**Heyford Park, Camp Road, Upper Heyford,  
Bicester, OX25 5HD**

**23/01959/NMA**

**Proposal:** Non-material amendment to 16/02446/F - amended elevation plans for 7 plots (plots 630-632, 634-635 & 646-647)

Drawing Title:
 HOUSE TYPE AF2
 ELEVATIONS

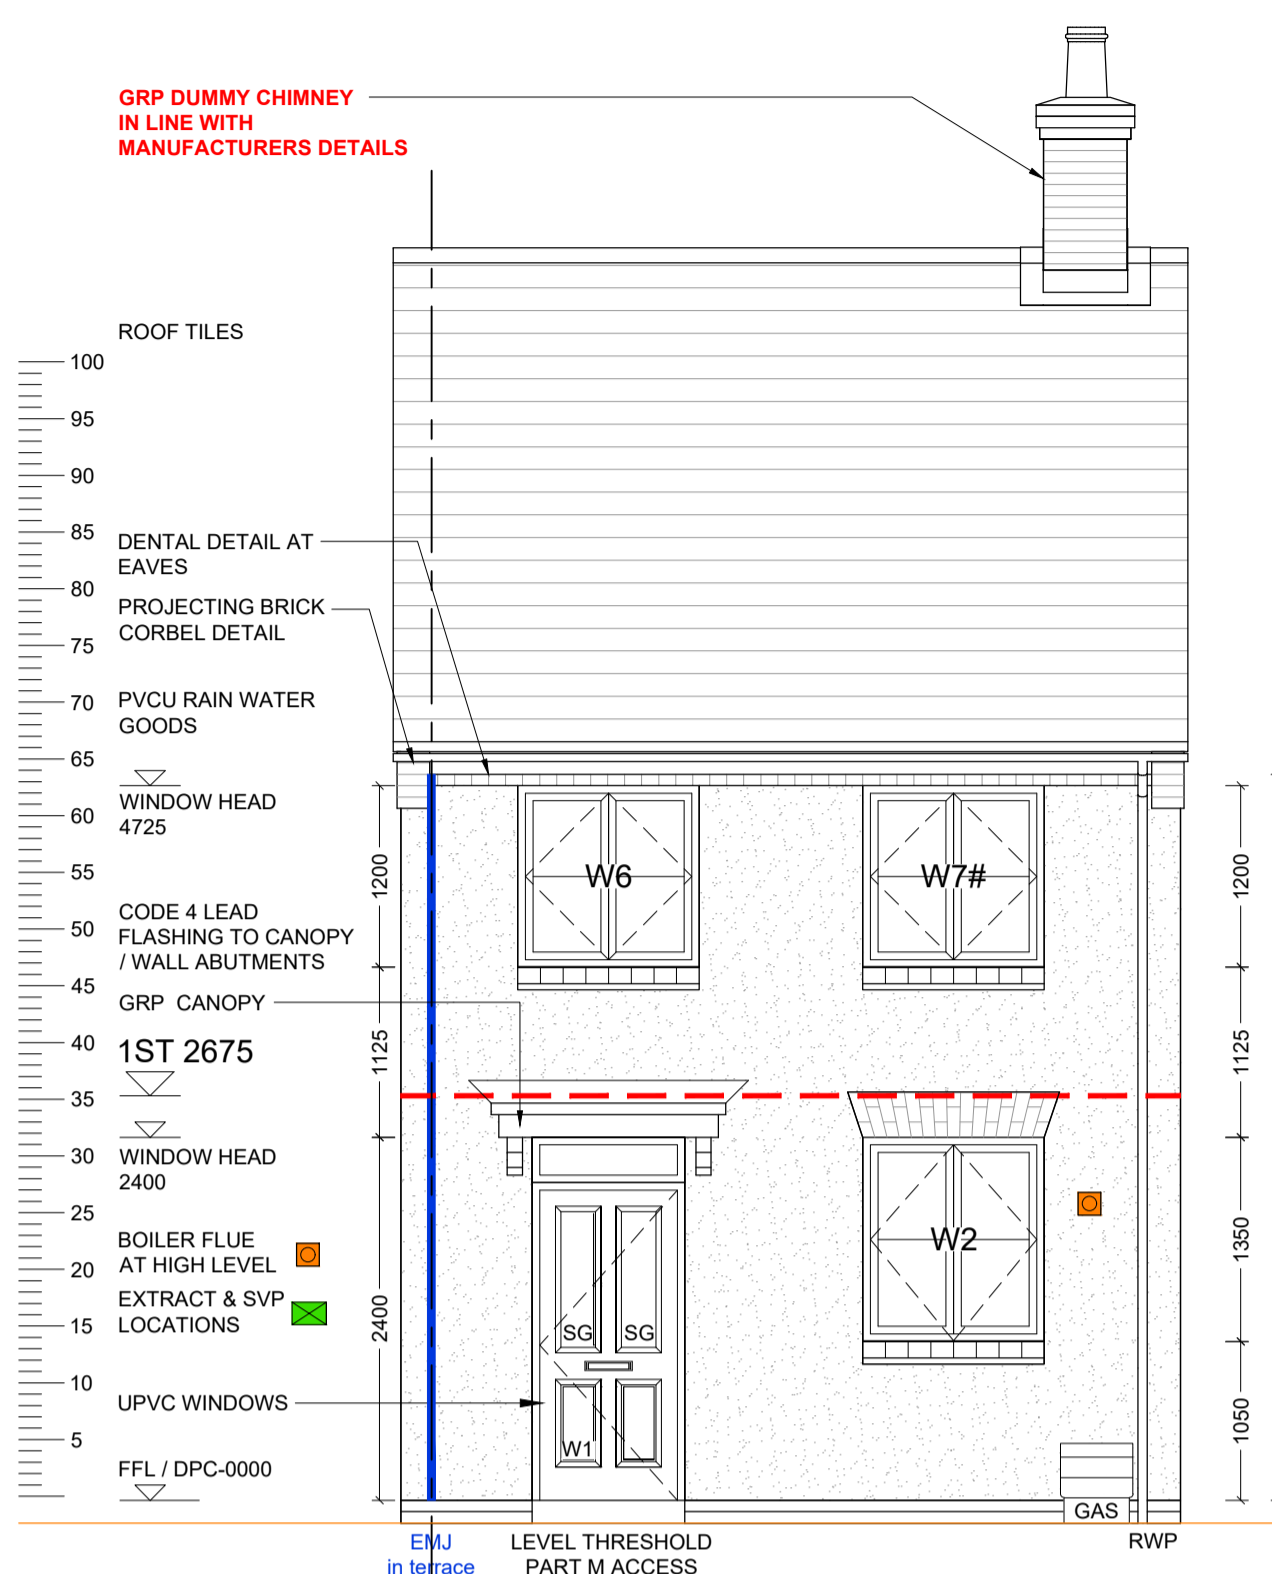
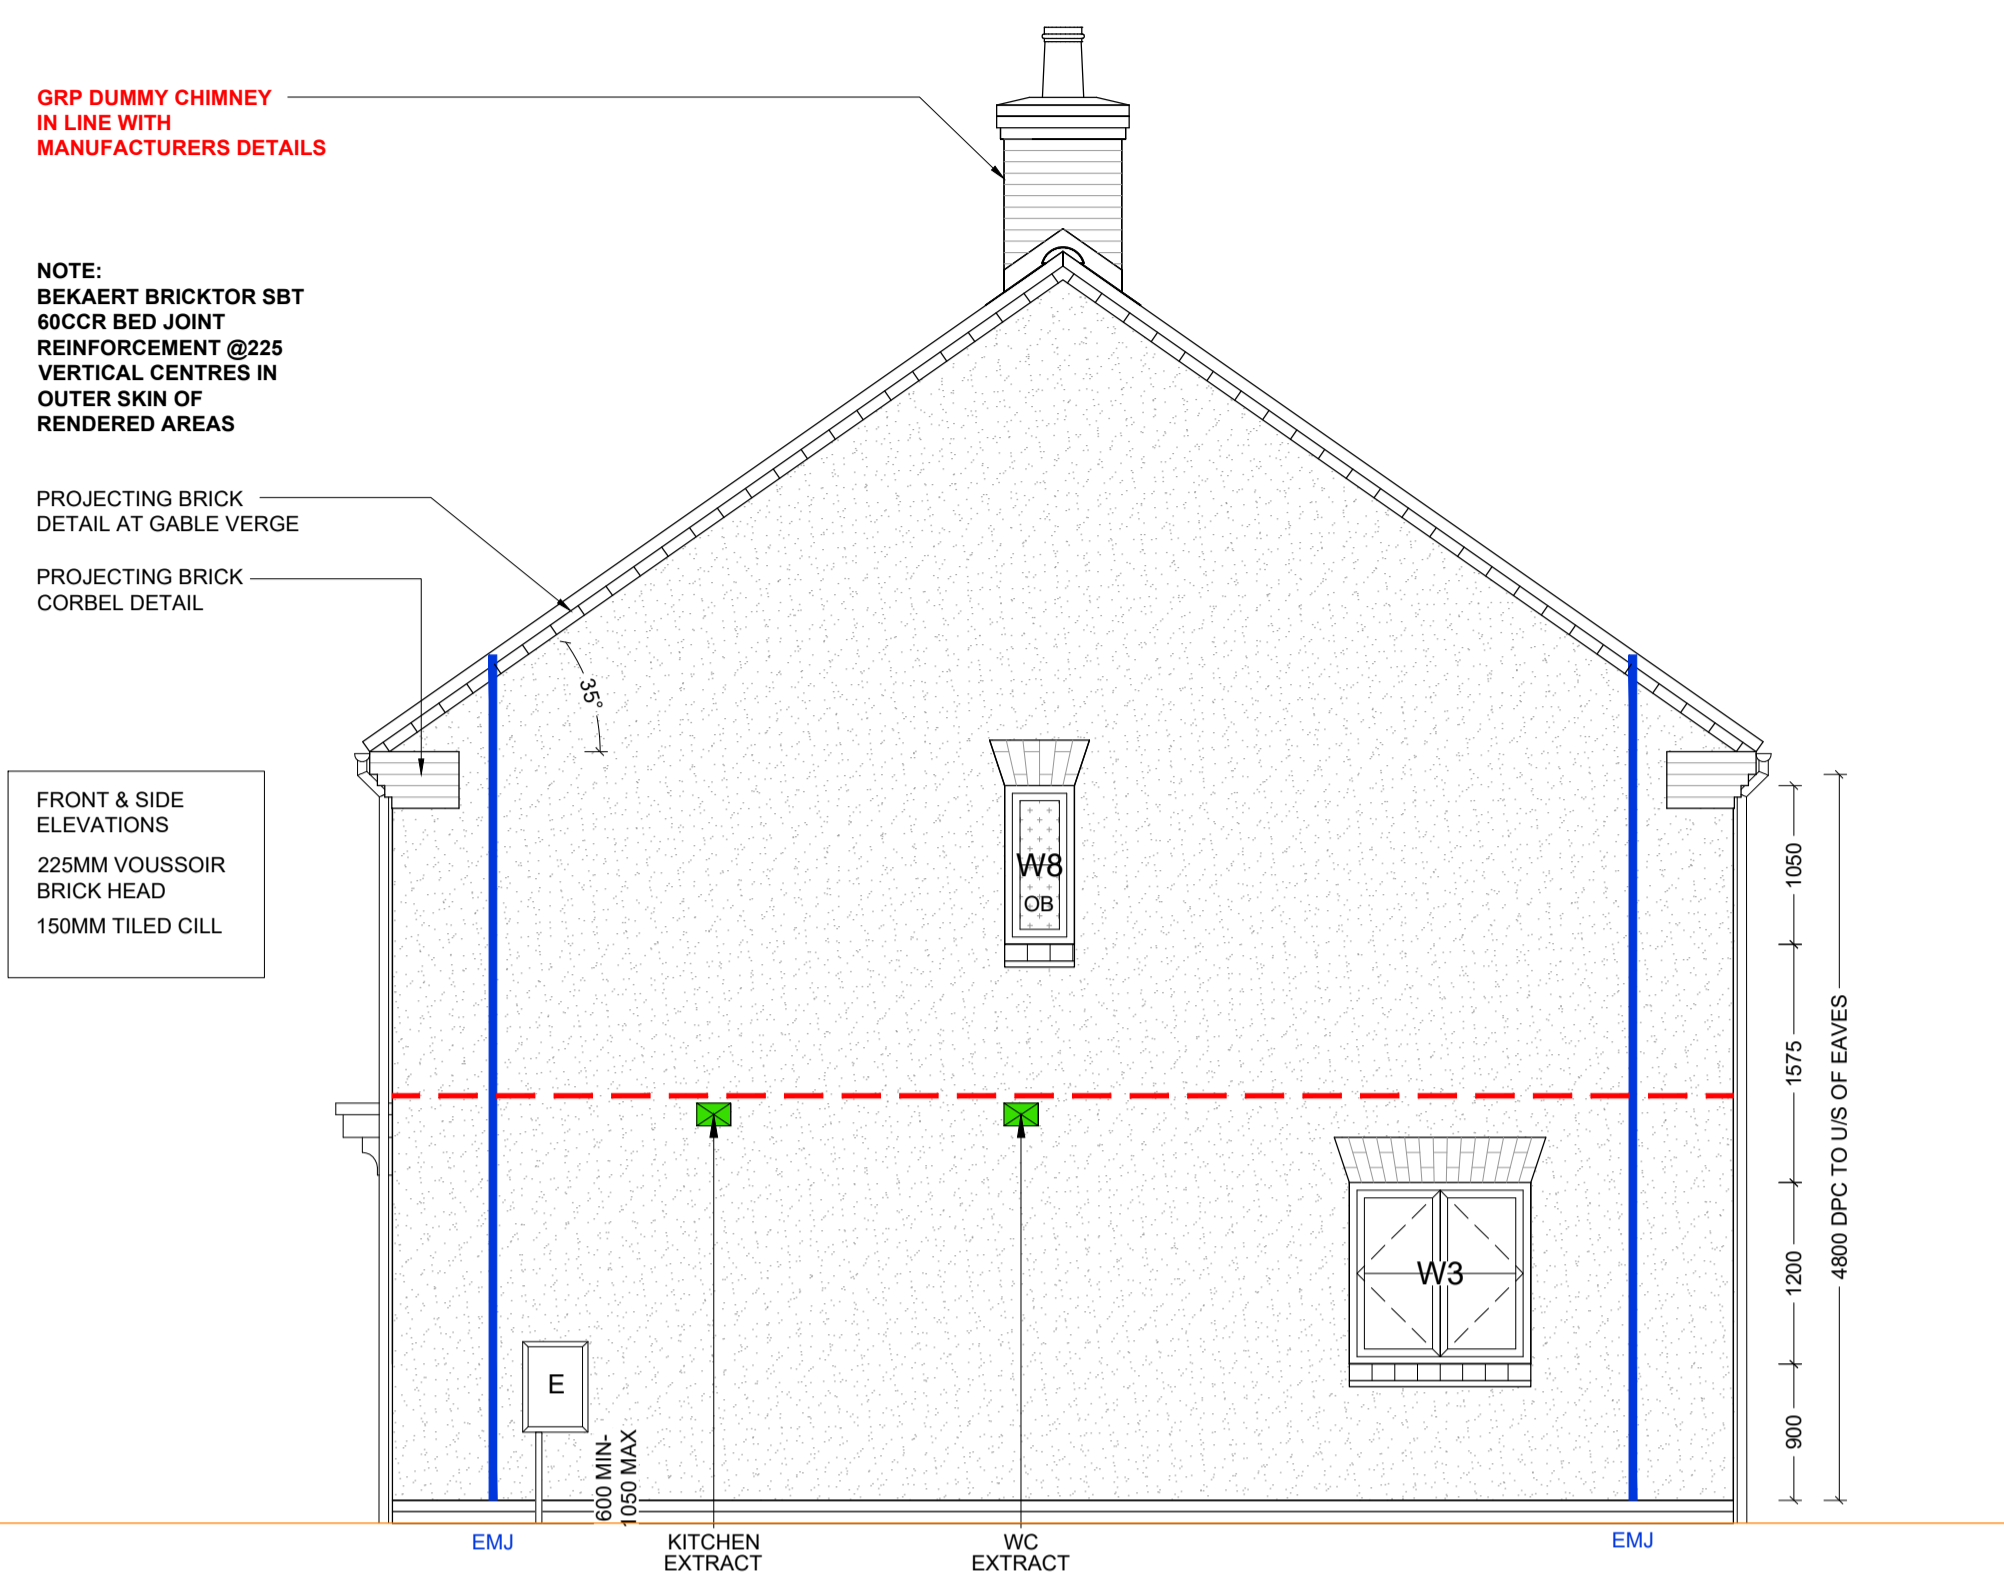
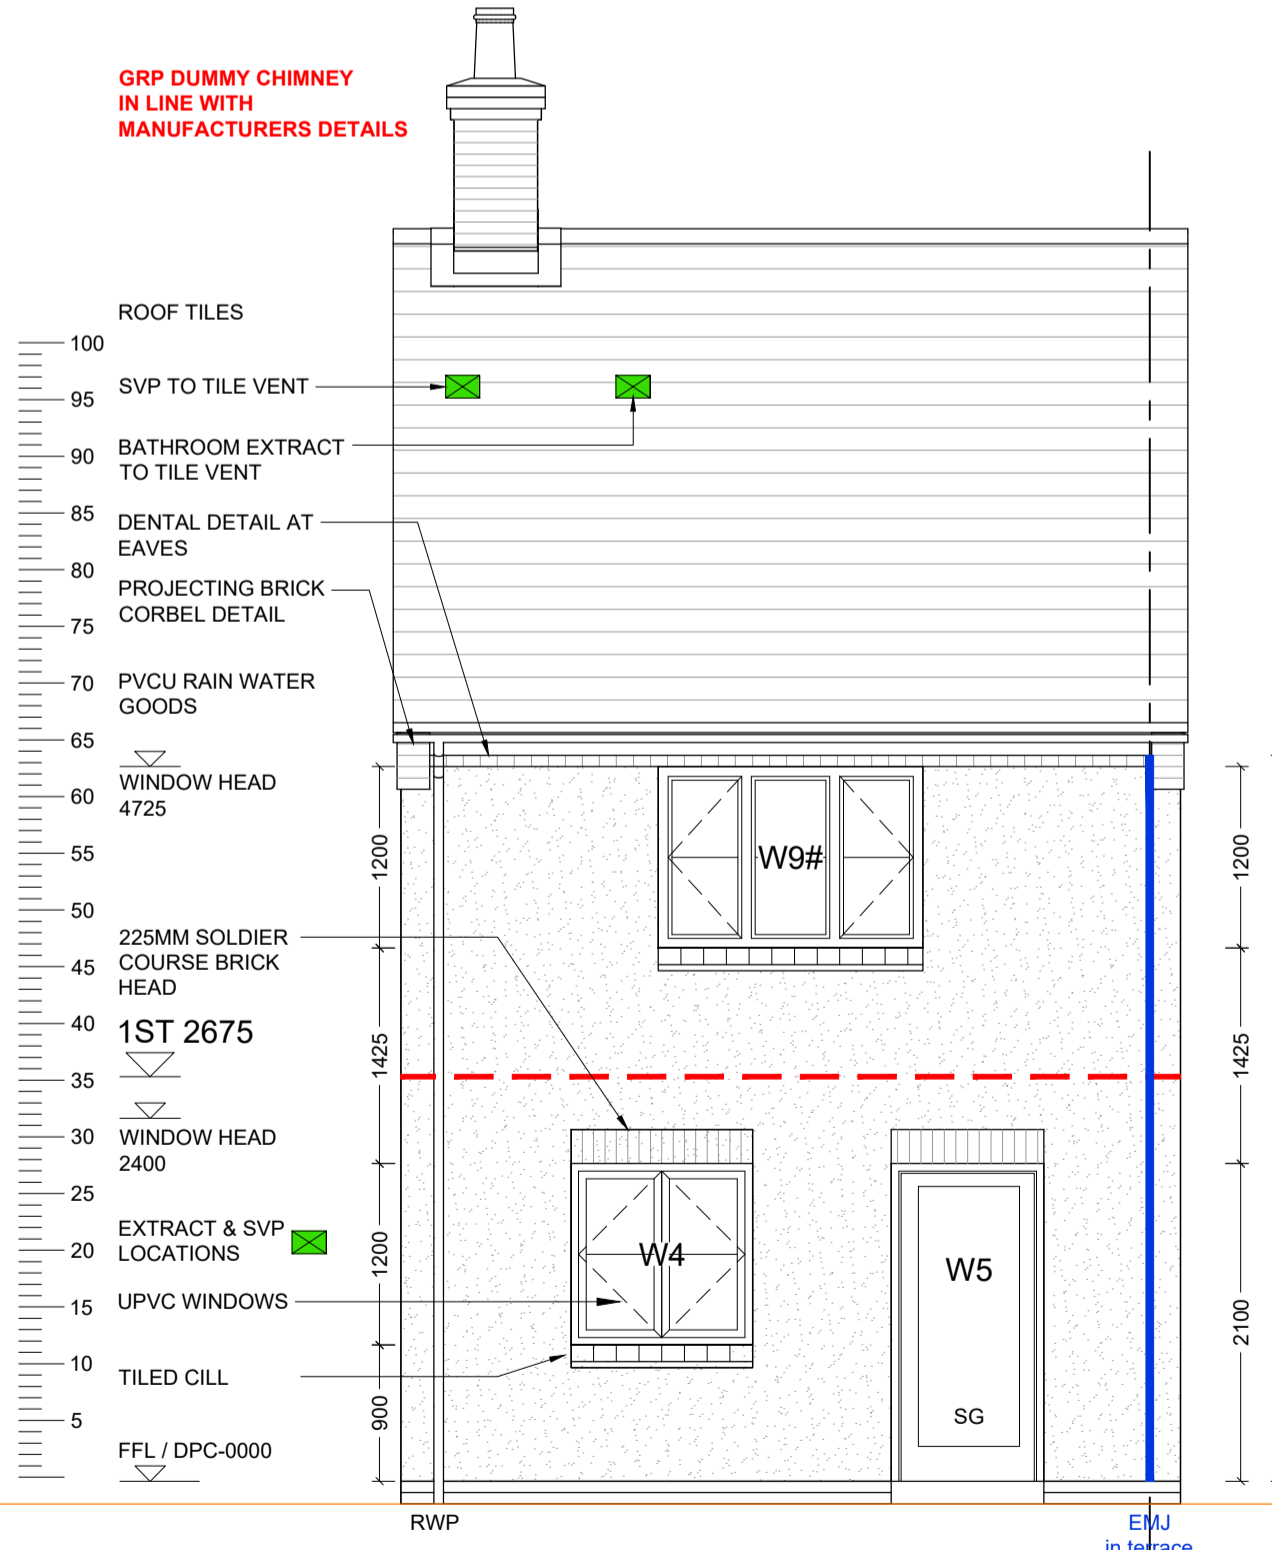
### House Type AF2 – Plot nos.646 and 647

- Bed 2 window to rear elevation increased to 3 panes;
- Fanlight added above front door;
- Windows increased in height.
